From: Simon Davis
Sent: 11 January 2019 16:14
To: Planning.Responses
Subject: FW: A18237C. Kings Beach Hotel (P/83/18/DOC)
Attachments: Western Catchment.pdf; Eastern Catchment.pdf; A18237-0201-C1 Typical Details-Layout1.pdf; A18237-0200-C3 Drainage Layout-Layout1.pdf; Surfacing check.pdf; Simulation Output.pdf; Porous Surfacing.pdf; HC, Kings Beach, Pagham, Drainage Test, 10 Dec 2018 Reduced File Size.pdf; New BRE Digest 365 soakaway spreadsheet.pdf

From: Andy Johnson [REDACTED]
Sent: 08 January 2019 13:18
To: Laura Gibbons [REDACTED]
Cc: 'Tom Hall' [REDACTED]
Subject: RE: A18237C. Kings Beach Hotel (P/83/18/DOC)

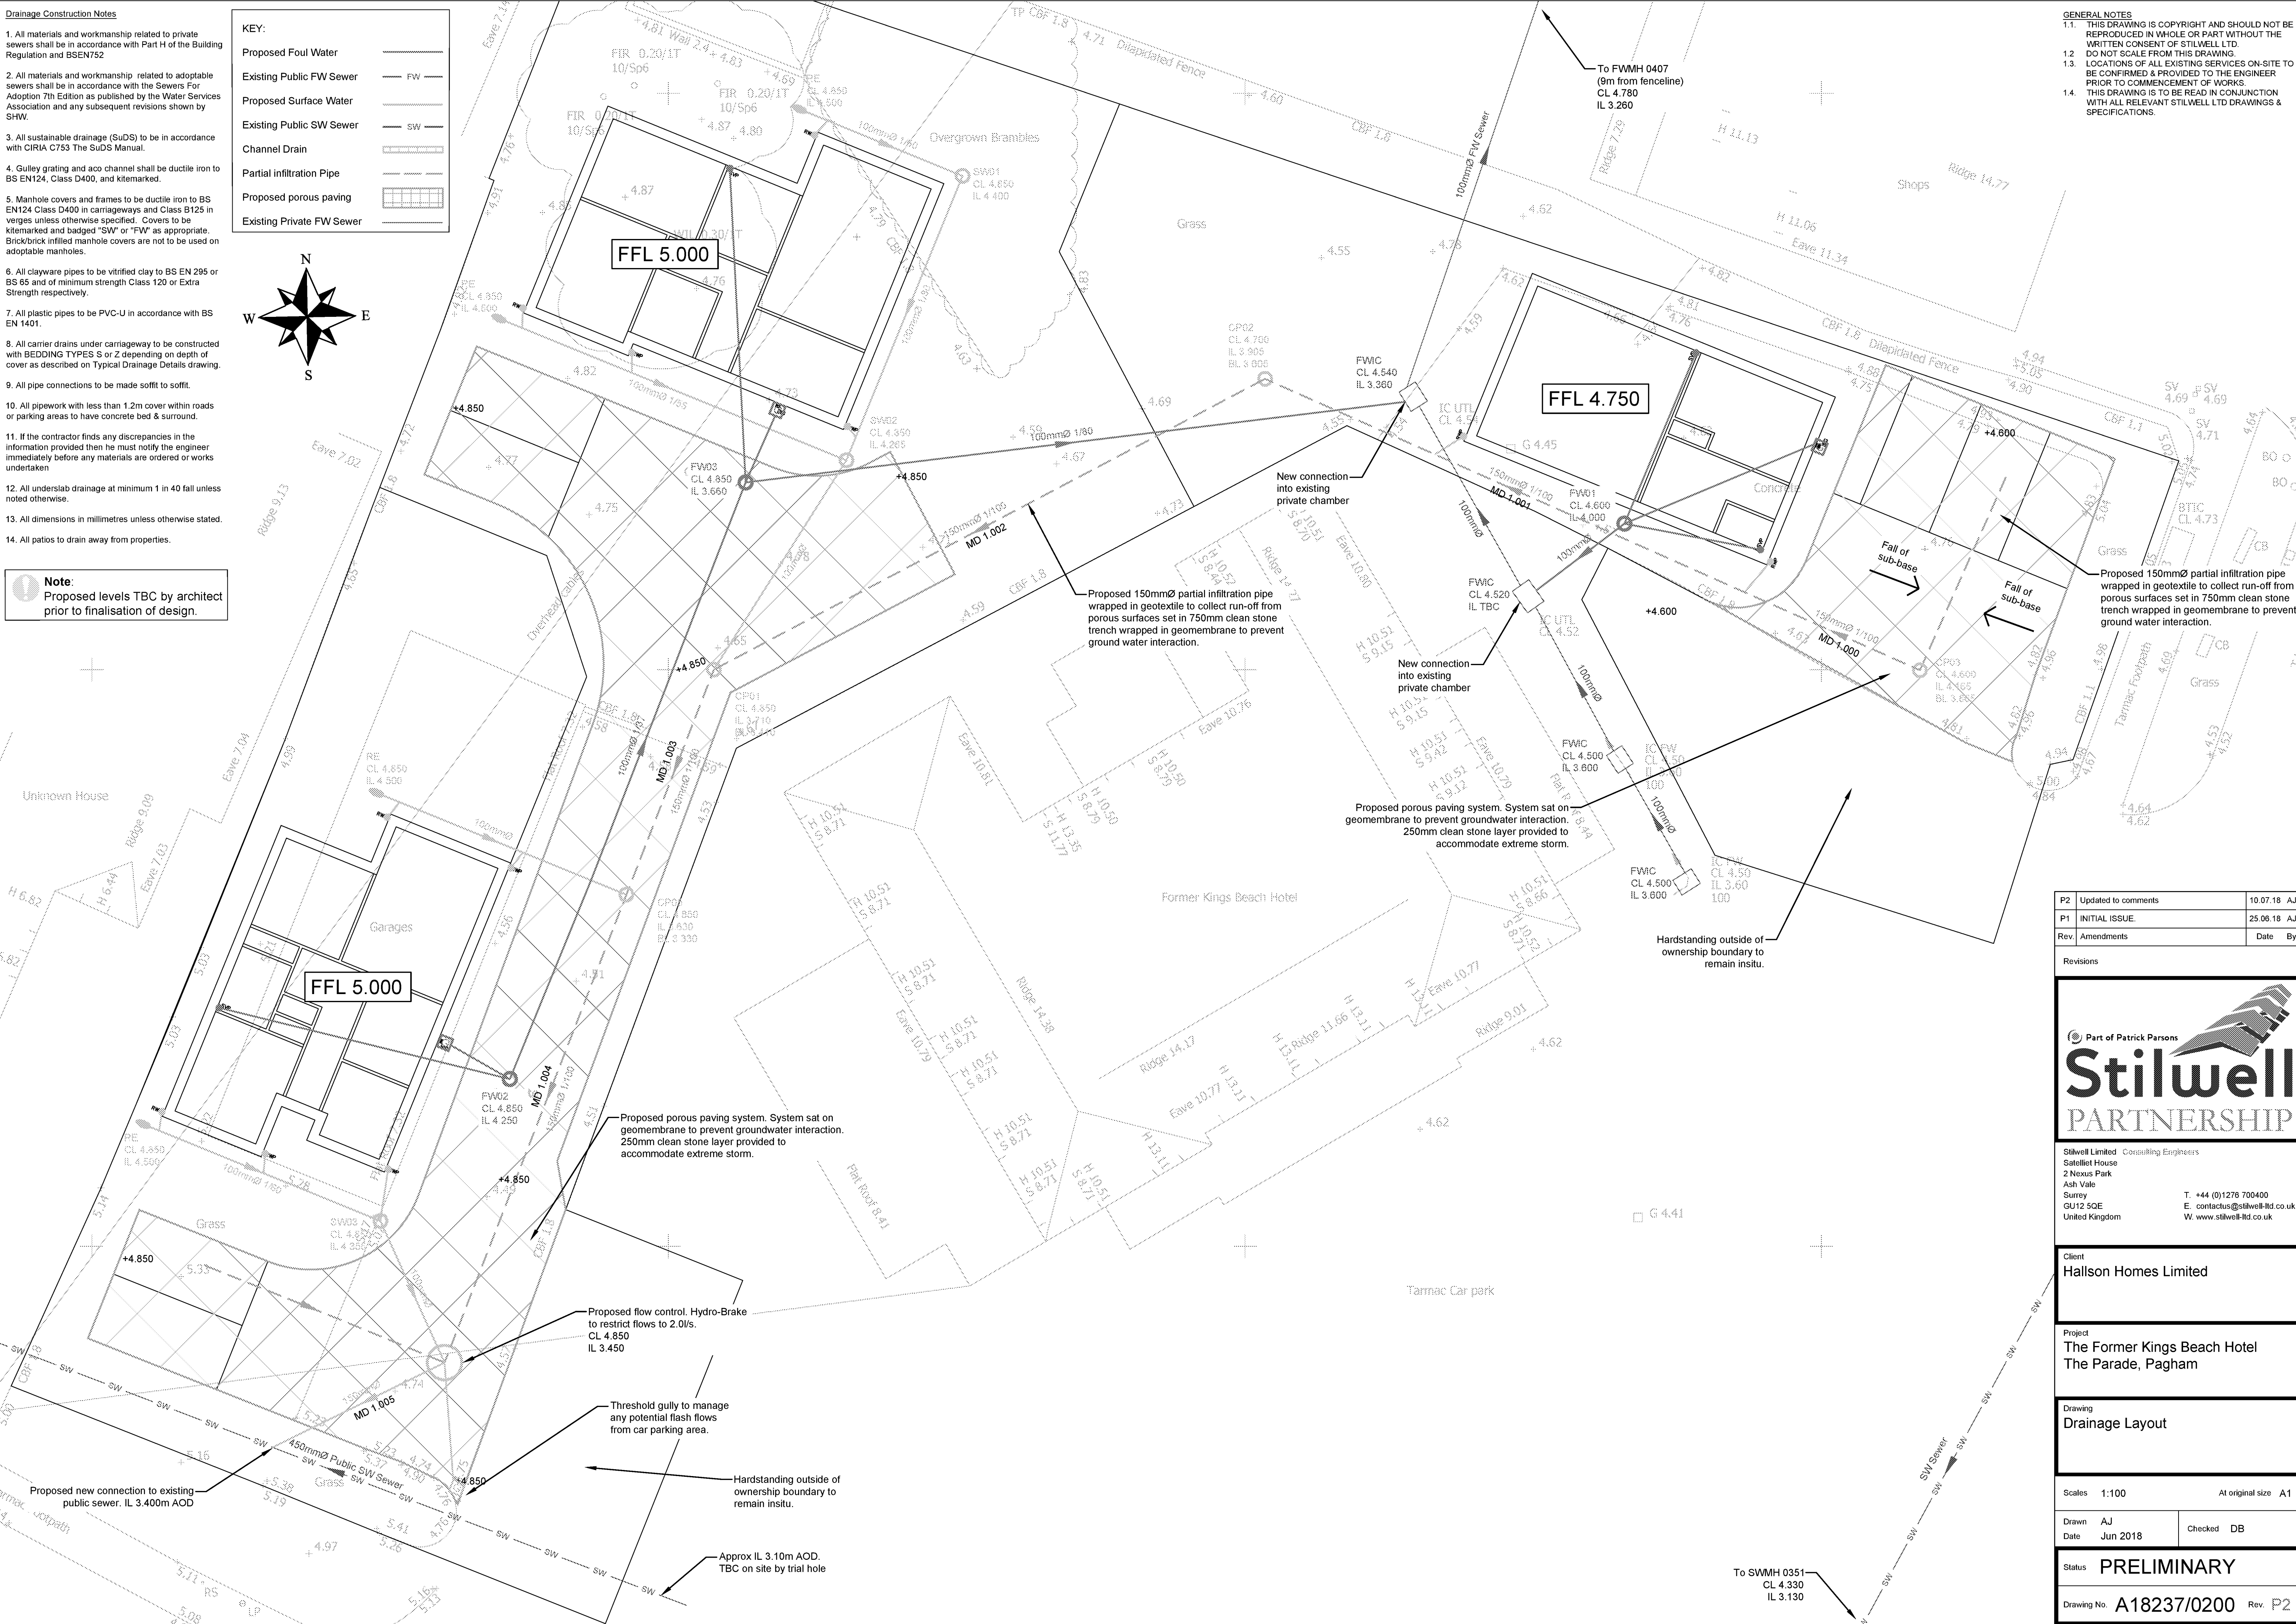
I do need to see the finish and formation levels specified on the layout plan too.

The calculations do not stipulate the capped depth of stone you state, you have only got invert and cover depths for the storage features. The difference between these is not equal to the depth of stone you stipulate, nor is there any other differentiation between void ratios of the various layers above the stone.

The stone depth required needs to equal or exceed the maximum water depth modelled. Either you model the invert and cover depths so that the difference is equal to the stone you propose, or you model total formation depths and take the maximum water depth calculated as the depth of stone required.

As a further check (which may help demonstrate my point) please ensure the free volume within the stone sub base is equal to or greater than the maximum water volume. If as you state in the eastern catchment you have 250mm of stone, free volume is $10 \times 9 \times 0.3 \times 0.25 = 6.75 \text{ m}^3$, this is less than the maximum volume of water of 10.4 m^3 . Therefore, the depth of stone needs to be increased.

The drainage layout submitted doesn't show the permeable paving extents. I don't know if the layer was just switched off or what. However, please ensure extents are shown and that the paving is labelled up with finish and formation level.

The calculations also demonstrate that 390mm stone is required in the west, and 460mm in the east. Please update drawings accordingly.

No problem. I used an arbitrary level on the calculations just to get the design done which may have caused some confusion. I have now updated to the correct levels (attached).

Also formation level and cover level shown on the drawing for completeness. I have increased the eastern side to 350mm, the calcs had a typo in which accounts for the error you noted. Many thanks and apologies for that.

The dimensions you noted are the overall construction depth. This allows for the topping and sand blinding, the input stone depth in MicroDrainage is capped at 250/350 as required.

Please find attached the updated pack. The system requires 250mm stone in the east side and 350mm stone in the west.
